# CITY OF ALBUQUERQUE

Planning Department  
Alan Varela, Director

**Re: Retail at 7 Bar  
10080 & 10088 Coors Blvd NW  
Conceptual Traffic Circulation Layout for DFT Approval  
Engineer's Stamp 9-25-24 (B14D010D)**

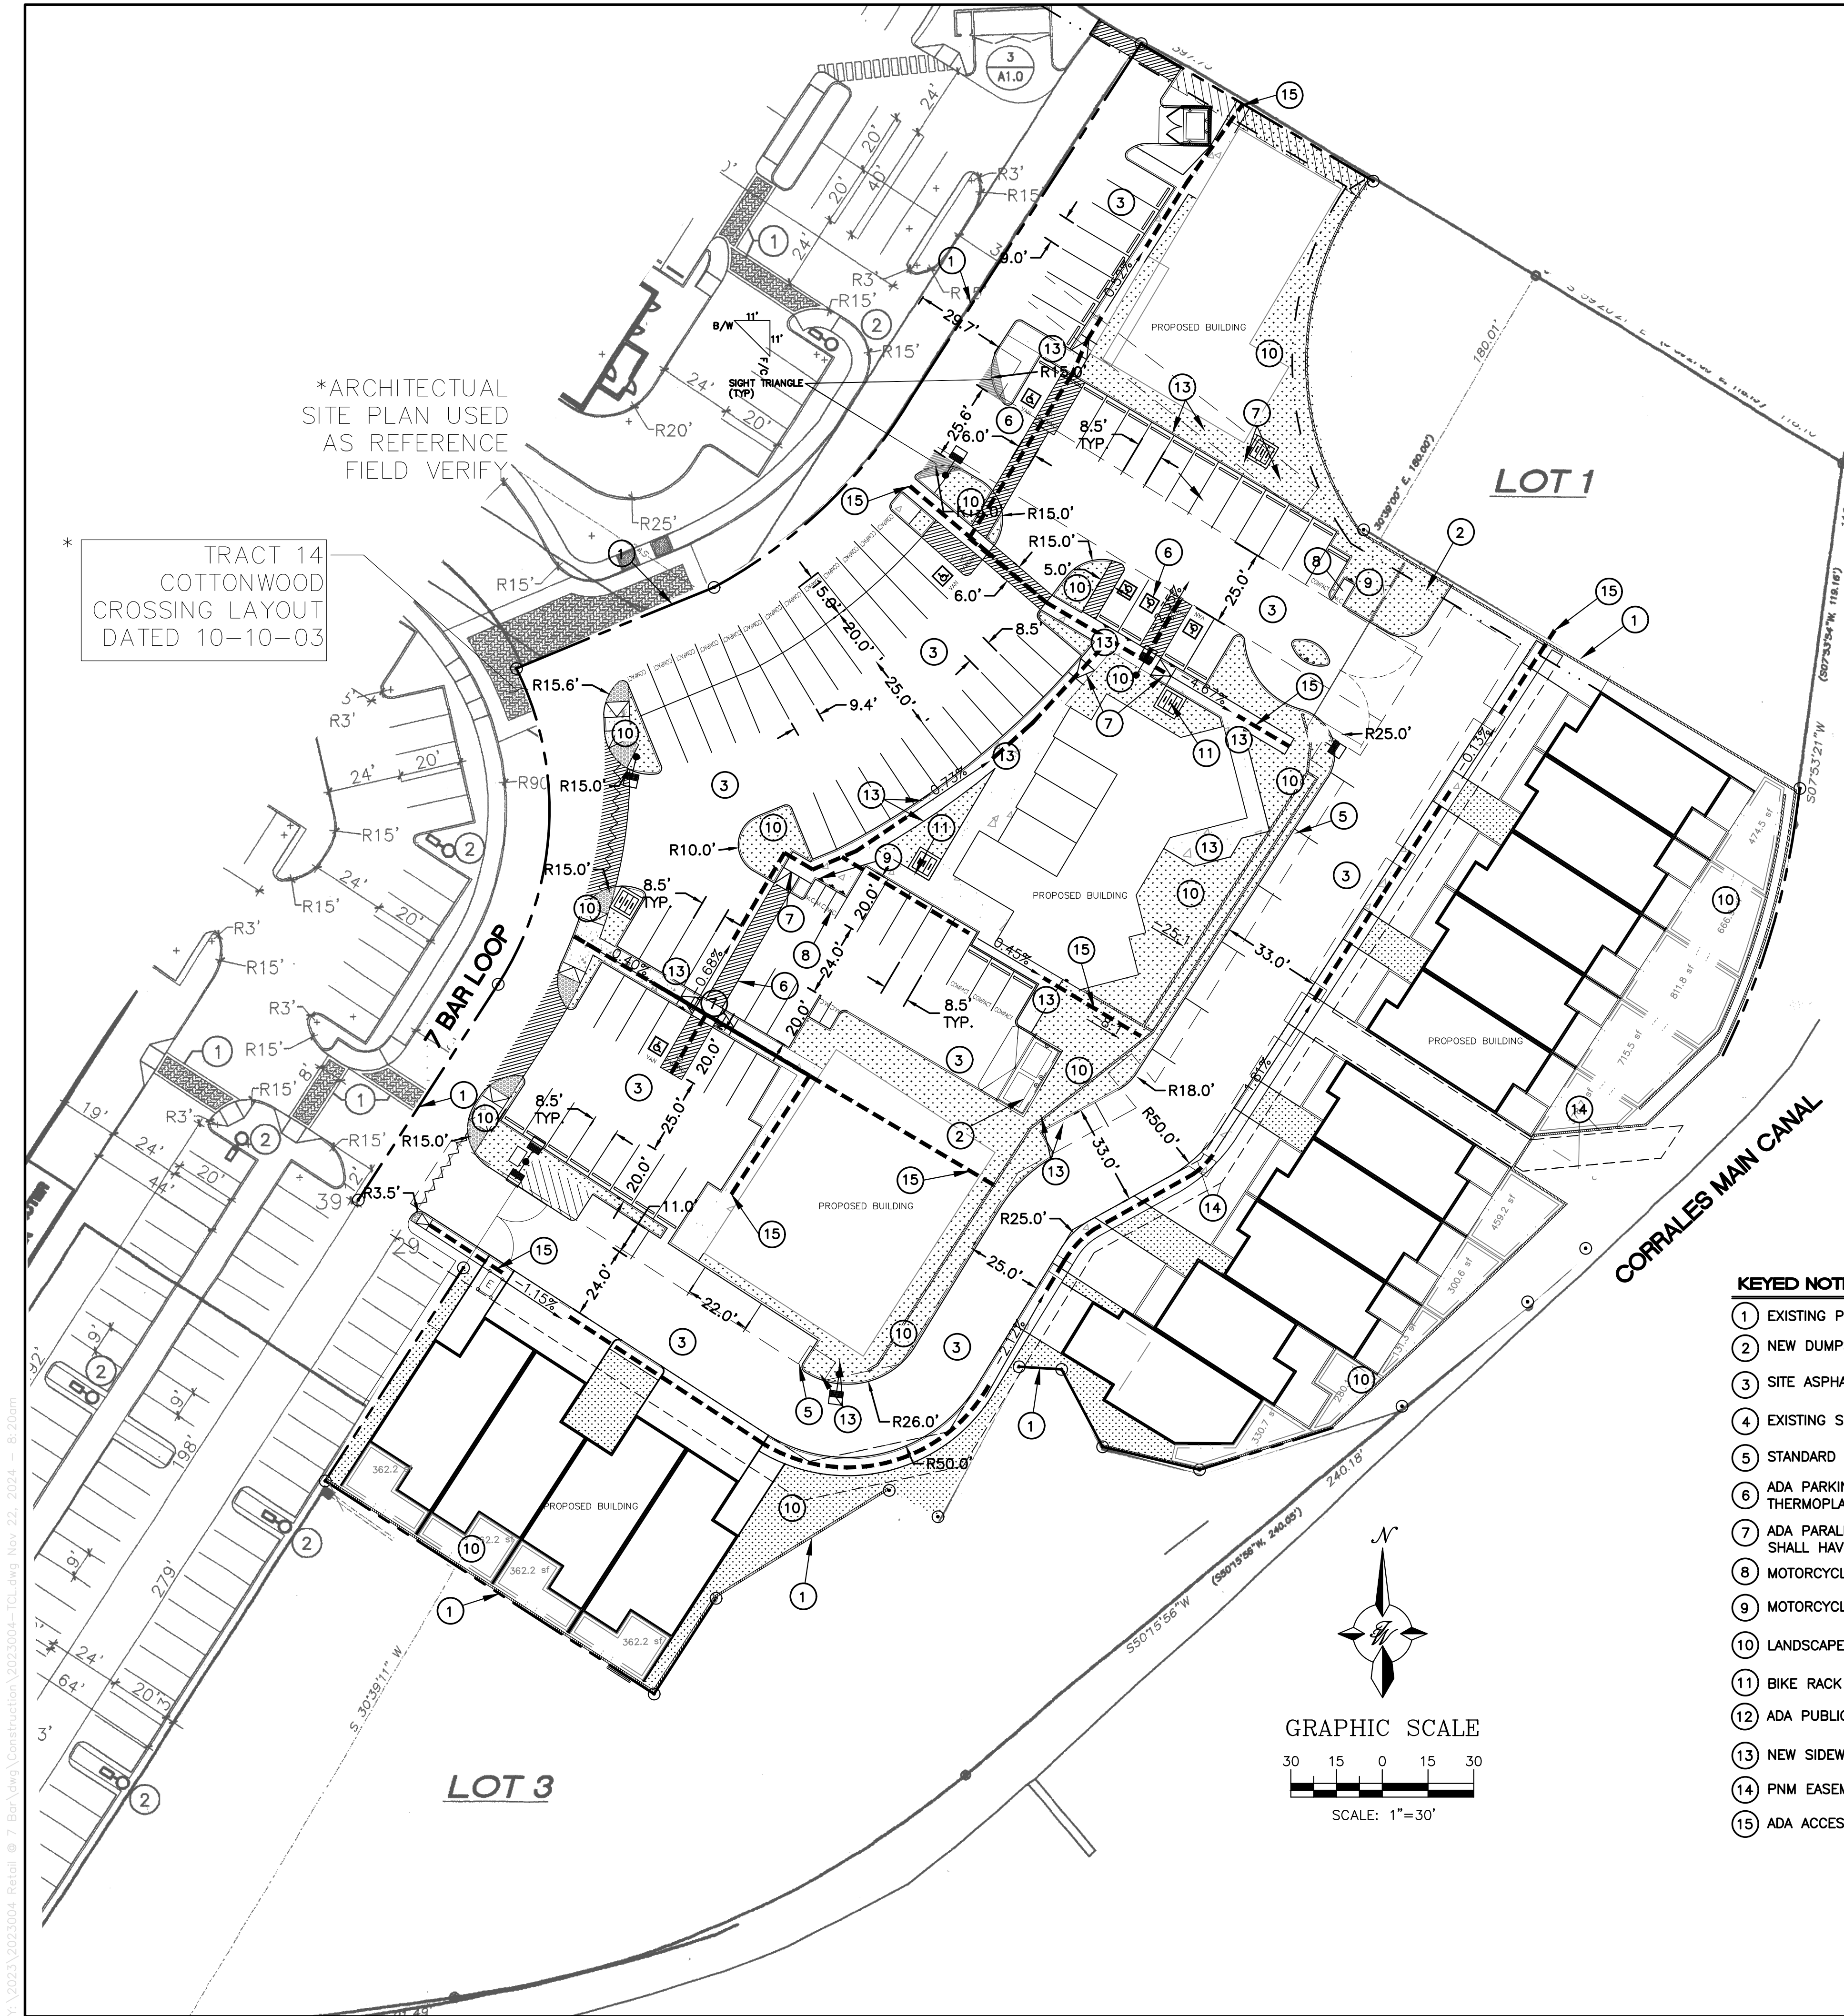
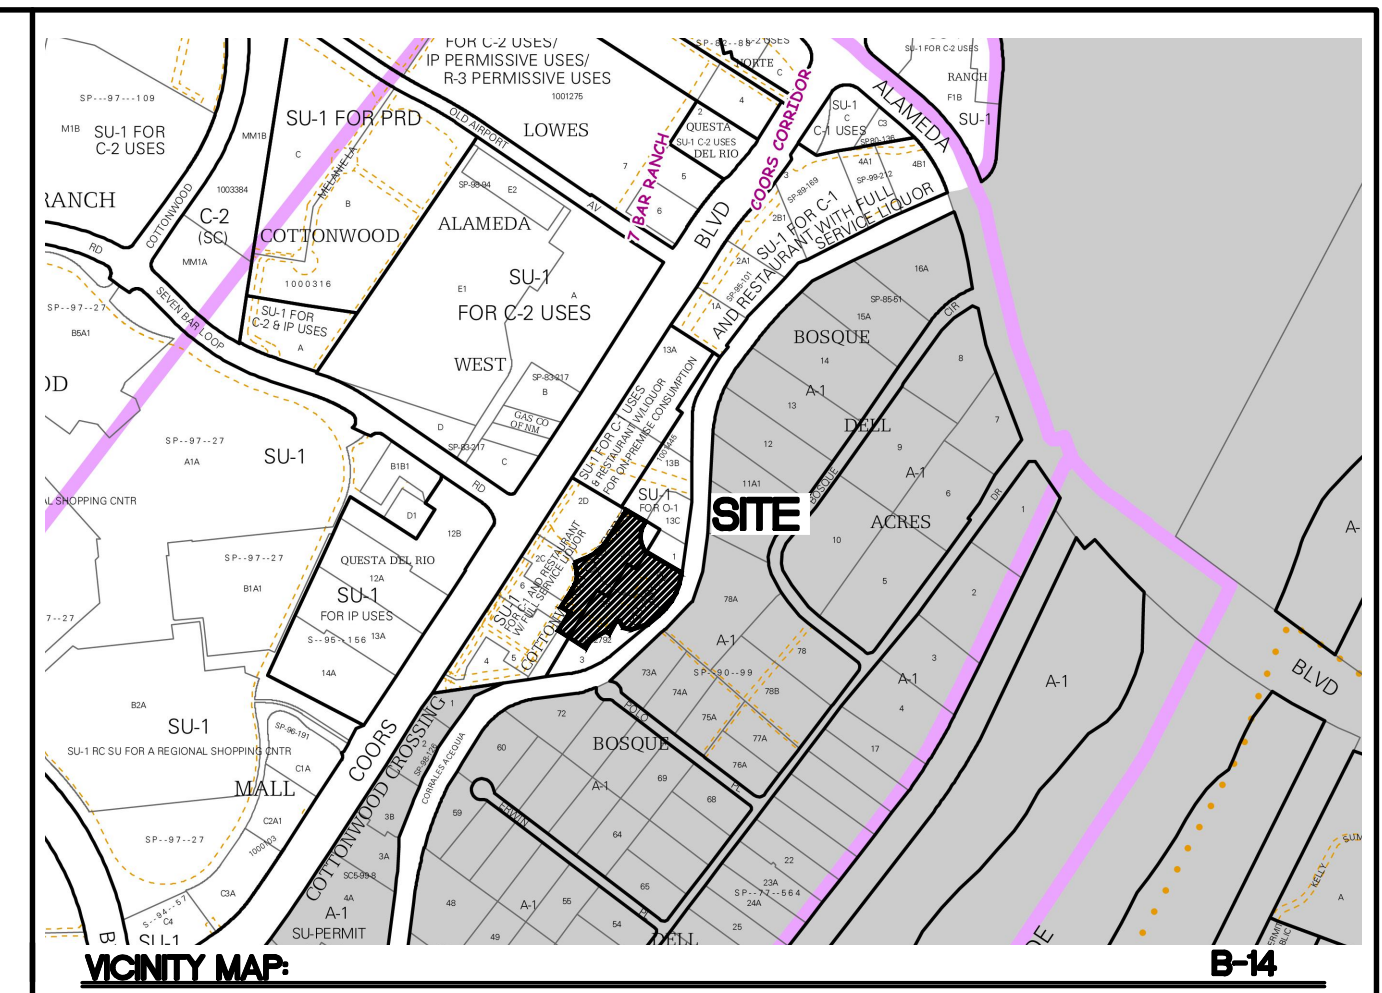
**1-A 5 ft sidewalk and 4-6 ft Buffer/Landscape are required along 7 Bar loop and the access road.**

**2-Show all the detail drawings**

**3-provide approval of fire marshal and solid waste dept.**

**4-submit TSF (see attached)**
